Review of the Environmental Impact Statement for the Crows Nest Over Station Development (Site A)

SSD-75660711

This report provides a review of the [Environmental Impact Statement](#) (EIS) dated 11 June 2025 and associated documentation submitted for the State Significant Development Application (SSDA) for the Crows Nest Over Station Development (OSD) Site A, identified as SSD-75660711.

Figure 3 Proposed Licensed Premises Roof Top Bar floor plan. Source: Woods Bagot

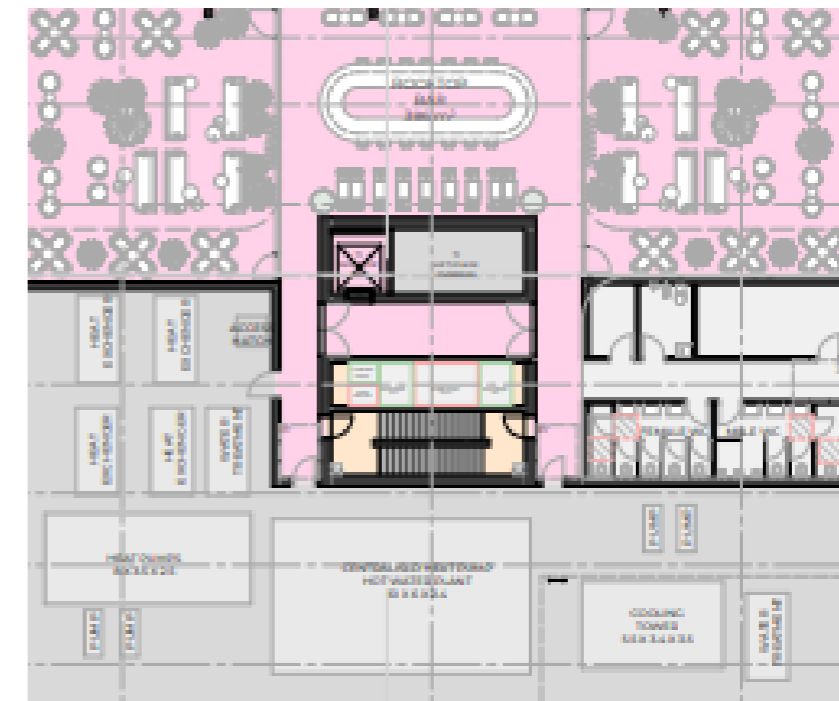
The proposal introduces significant and inherent land-use conflicts by co-locating a 250-patron rooftop bar and other ground-floor licensed premises within a high-density building containing 474 residential apartments. This design choice directly

The [Noise and Vibration Impact Assessment](#) (NVIA) proposes a suite of standard mitigation measures, including a 3-metre-high solid parapet around the rooftop bar, limits on amplified music to 70dB(A), and a 12 midnight operational curfew. Based on these measures, the SIA concludes that the residual risk to amenity is "Low". This assessment appears overly optimistic and incongruous with the lived experience of such vertical mixed-use arrangements.

The primary amenity impacts extend beyond simple acoustic compliance at a receiver point. They include cumulative noise from patron activity, queuing for lifts, and dispersal onto public streets late at night. They also include potential conflicts in shared spaces such as lobbies and lifts, and general security concerns. The EIS mentions "Separate rooftop bar access off Pacific Highway", but the architectural plans and operational management details are insufficient to demonstrate how this will be effectively and safely managed to prevent conflict with residents entering and exiting the building.

The reliance on operational controls, such as curfews and security management, is a weak mitigation strategy that is prone to failure and leaves residents with little recourse. The design itself does not appear to have robustly engineered the separation of these incompatible uses. This design choice appears to prioritize commercial activation and commercial yield with the creation of a "destination" venue, over the protection of internal and neighbouring residential amenity, risking the creation of a building with endemic social conflict, high resident turnover, and a poor reputation. This outcome would directly undermine the stated strategic goal of providing stable, long-term rental housing. Moreover, no consideration is given to the impact of disbursing large numbers of intoxicated people late at night/early morning into the surrounding neighbourhood, with the expected noise disturbance, violence, vandalism, etc. issues – the proponent has externalised the cost of loss of surrounding neighbour amenity.

4. **Resolved Amenity Conflicts:** Provided a revised design and a more robust Operational Management Plan that convincingly demonstrates how the amenity of 474 residential dwellings and surrounding neighbours will be protected from the impacts of the 250-patron rooftop bar and other licensed premises. This must include detailed plans for managing access, security, and acoustic and light spill impacts.
